FAO: Planning Department,  
Welwyn Hatfield Borough Council

Ref: 6/2018/0136/LB  
Date: 22/10/2019

## HISTORIC BUILDINGS AND CONSERVATION ADVICE

**RE: *Oshwal Centre, Coopers Lane, Northaw, Potters Bar, EN6 4DG***

DRAWING TITLE
WINDOWS 46-47-48

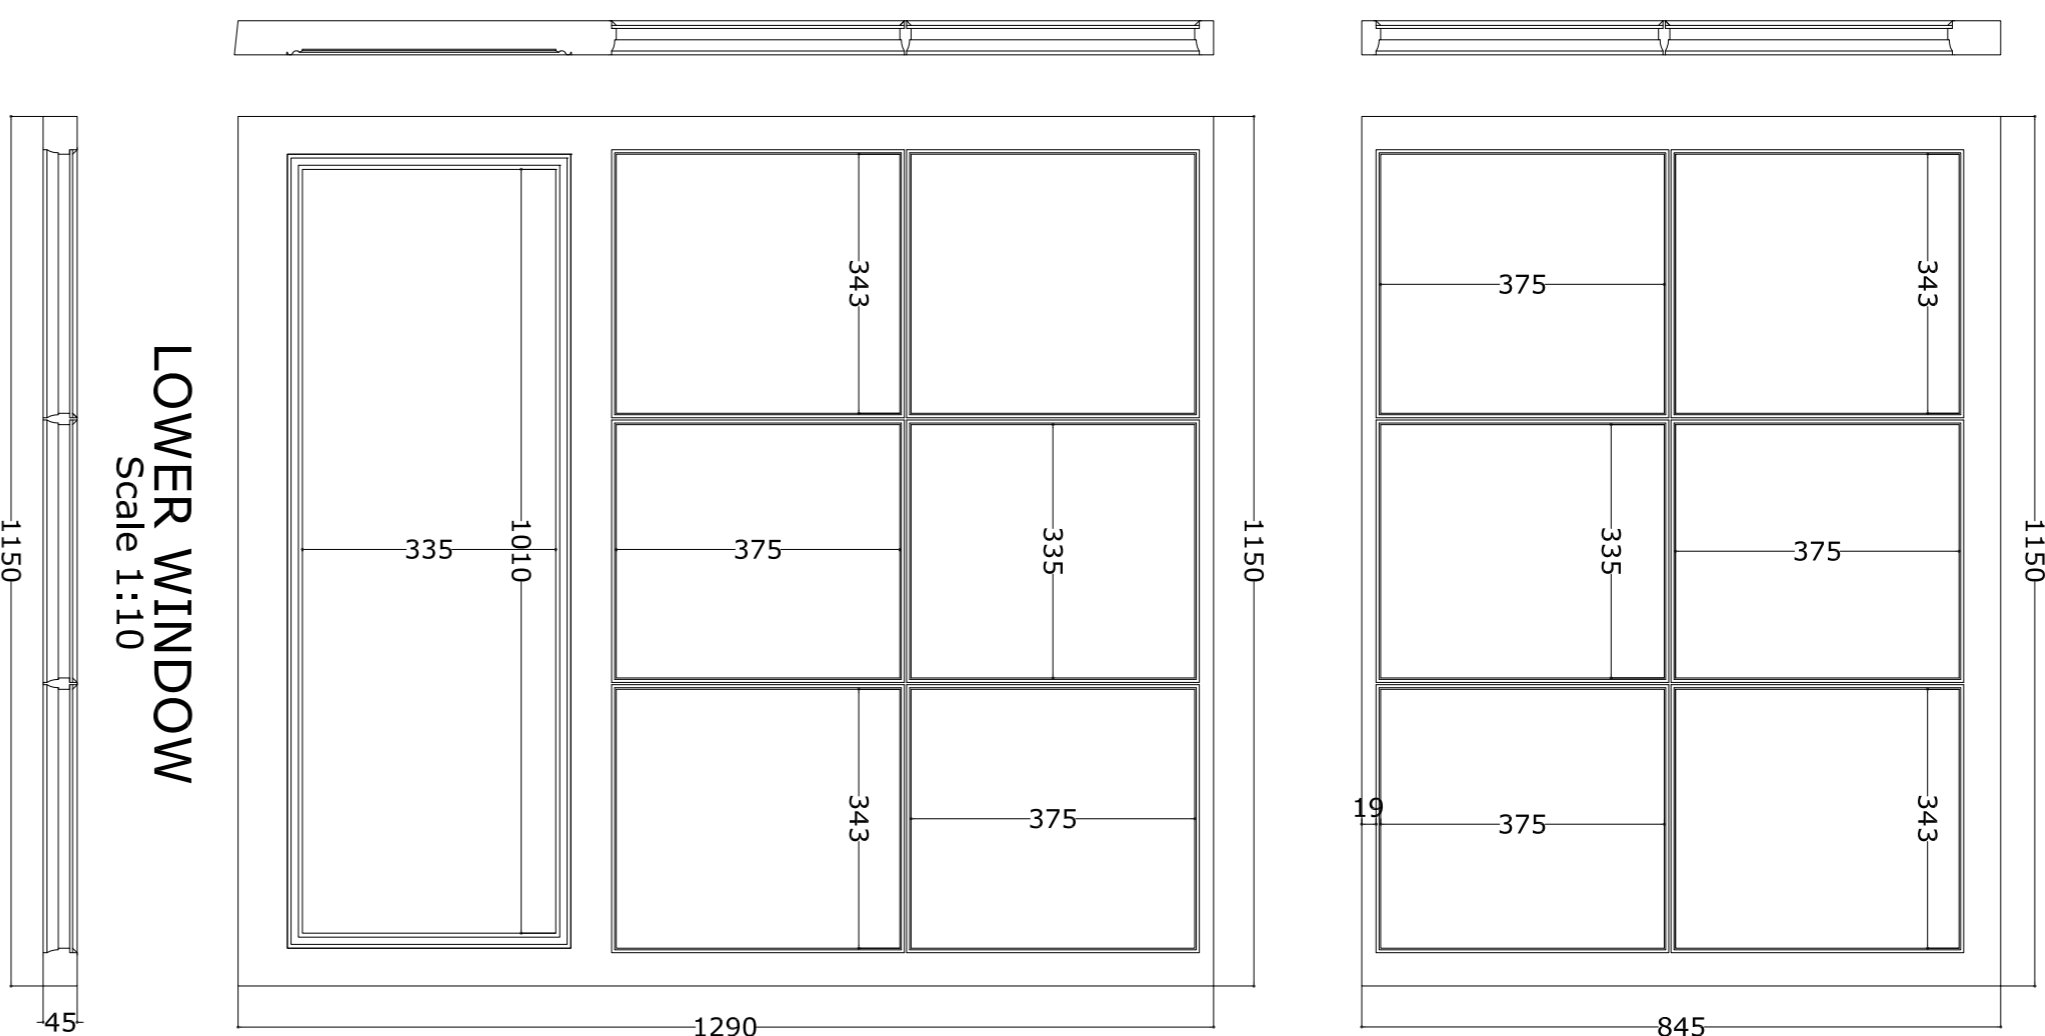
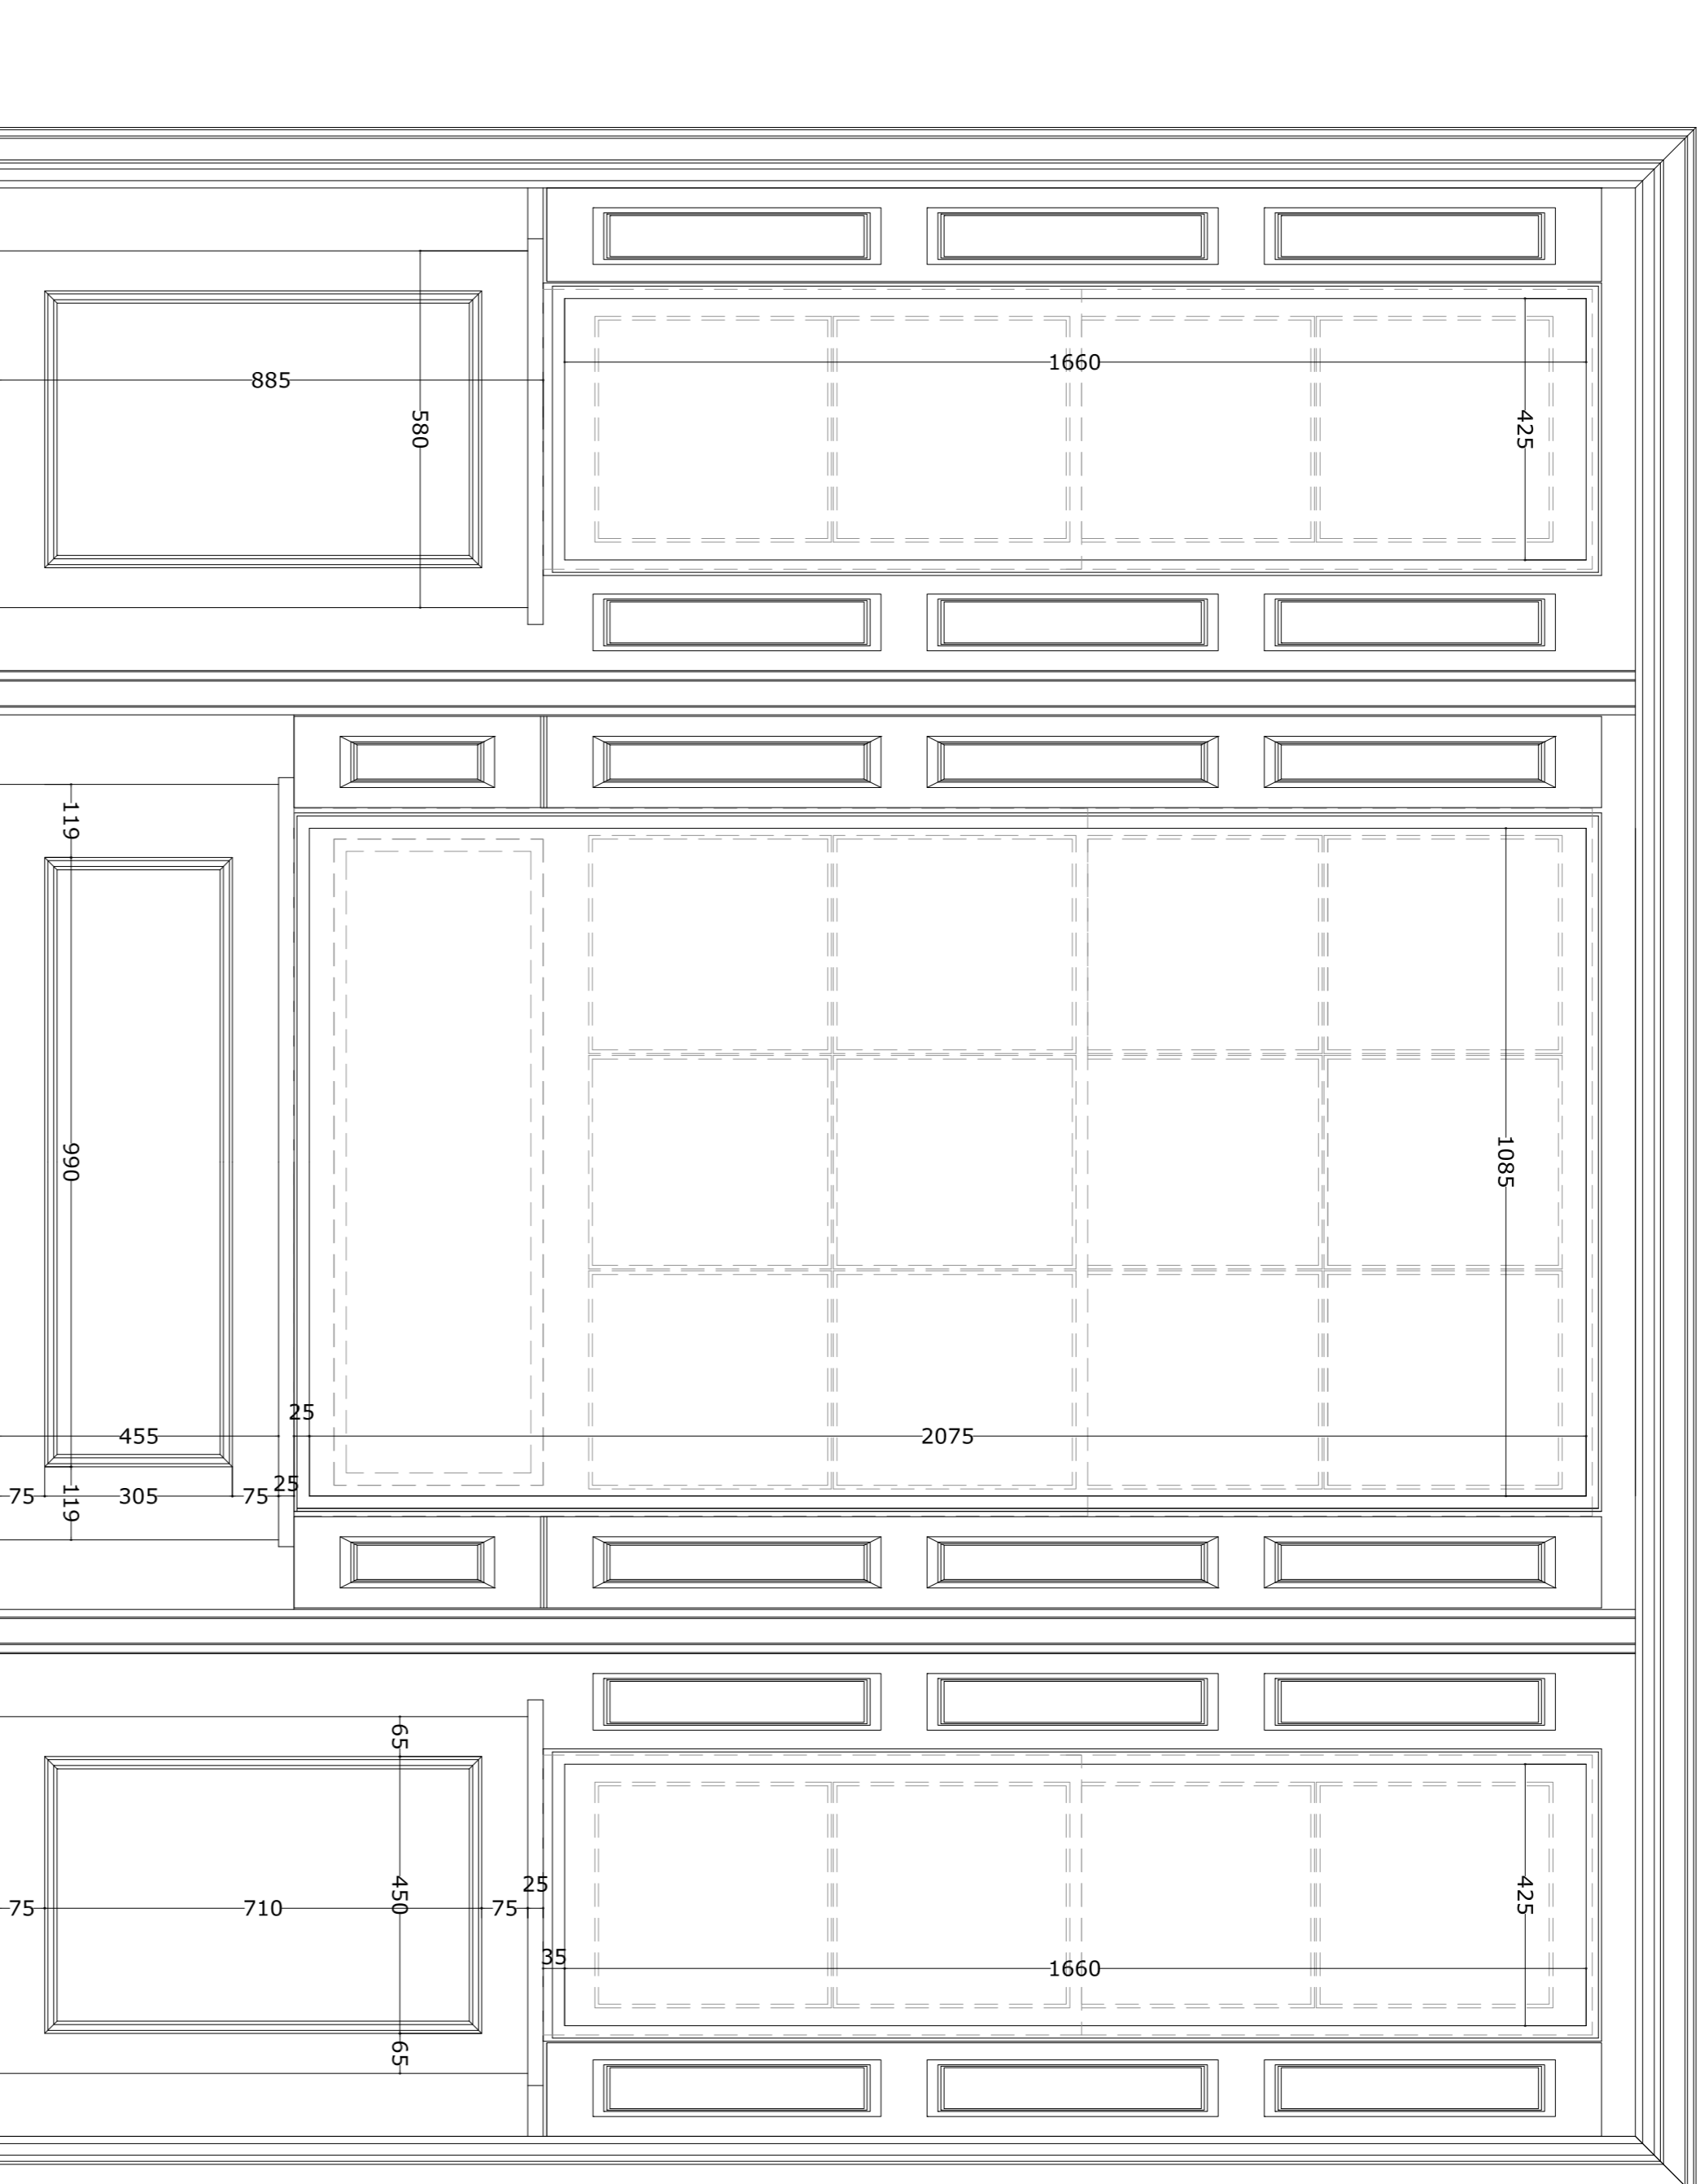
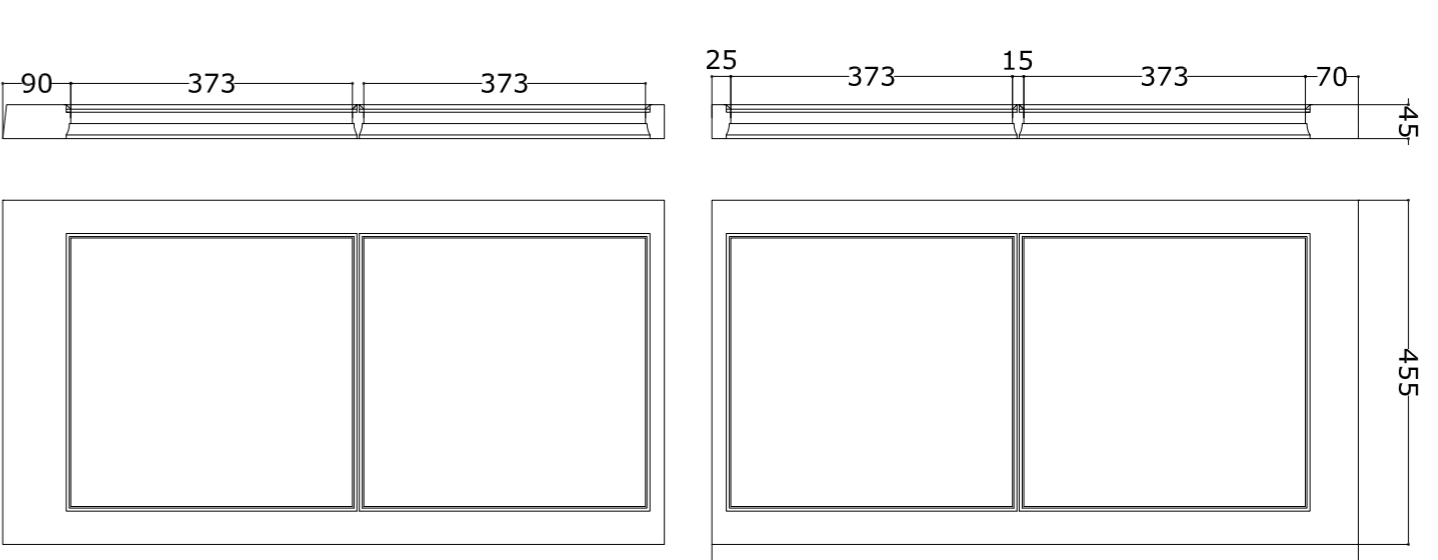
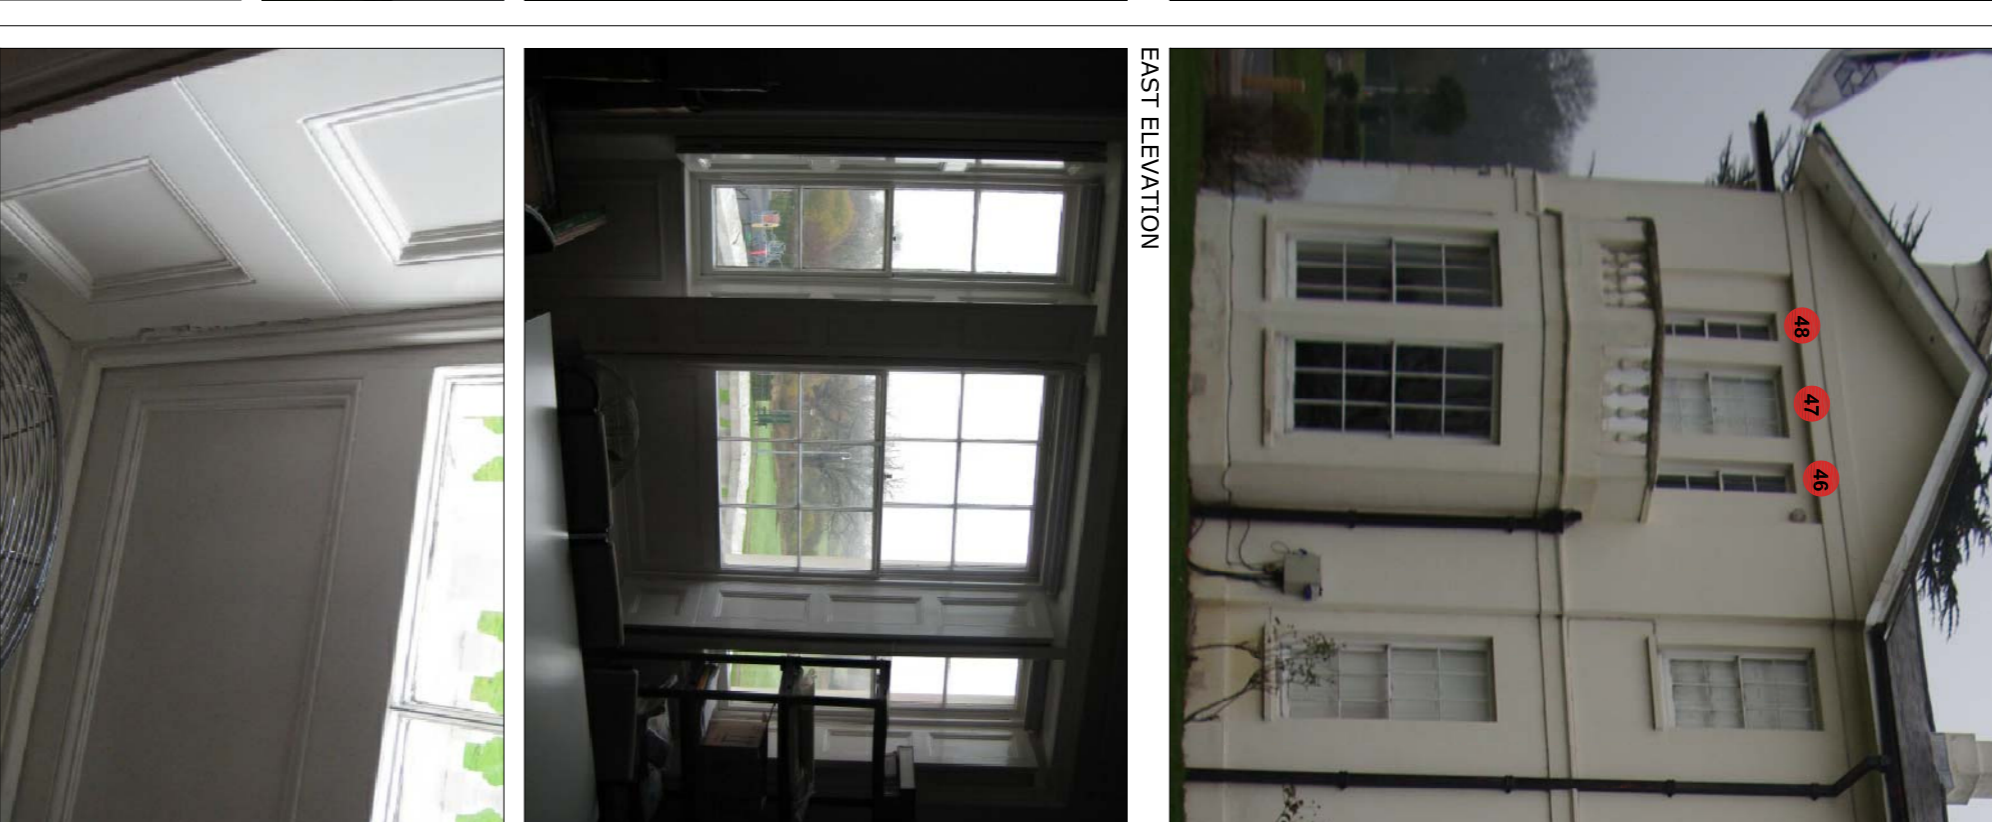
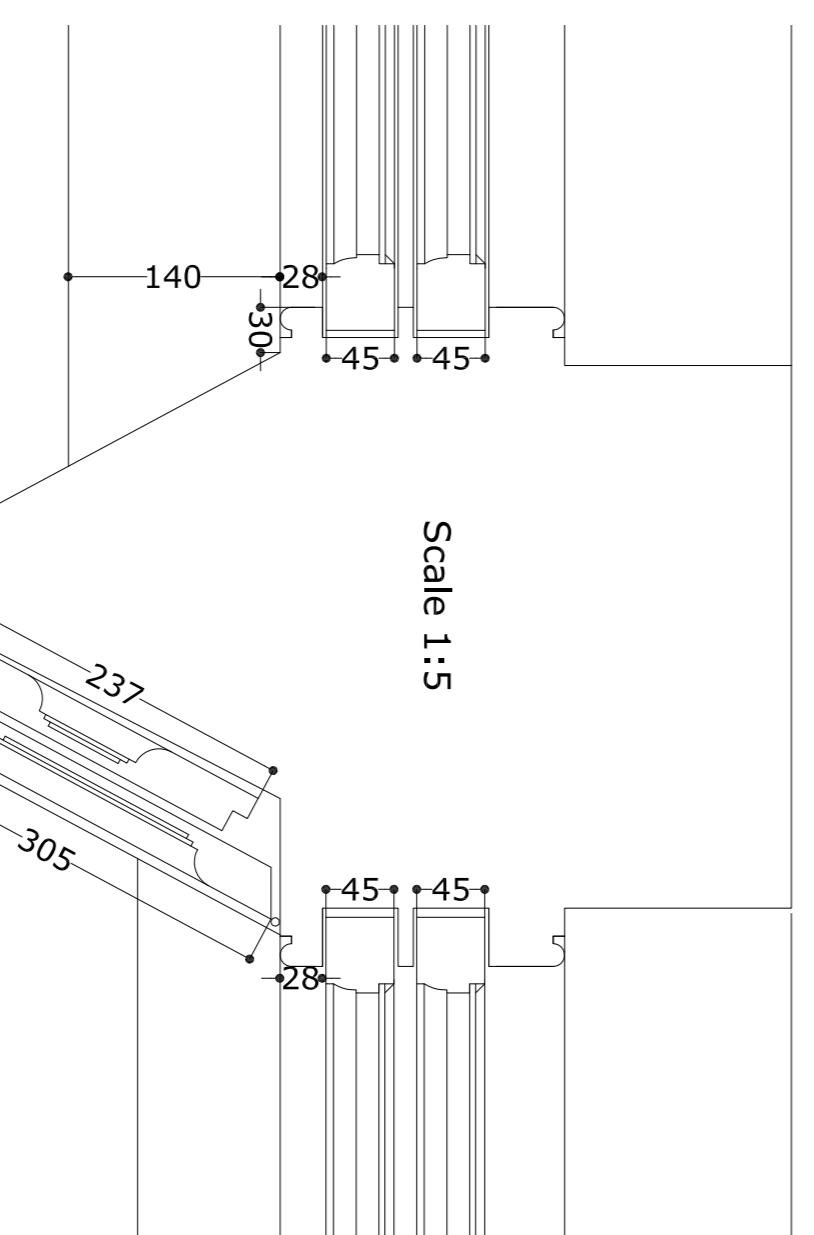
The repair of window nos. 1, 2, 3, 12, 13, 14, 15, 16, 17, 18, 20, 21, 22, 23, 24, 25, 26, 38, 39, 40, 41, 42, 43, 44, 45, 46, 47, 48 (refer to paragraph no. 2.11 of the *Heritage Statement Annex 1* and drawing no. 6842-78-P0) is supported. These windows appear to be original to the 1839 section of the house and therefore relate to the primary phase of the building. However, further detail is required on the repair needed to these windows as the *Heritage Statement* is quite general. Detail is required as to the extent of the repair work, the technique/methodology materials to be used. The proposed replacement of the single glazing with slim double glazing is not acceptable because of the potential loss of historic glass and the untraditional modern appearance of double glazing.
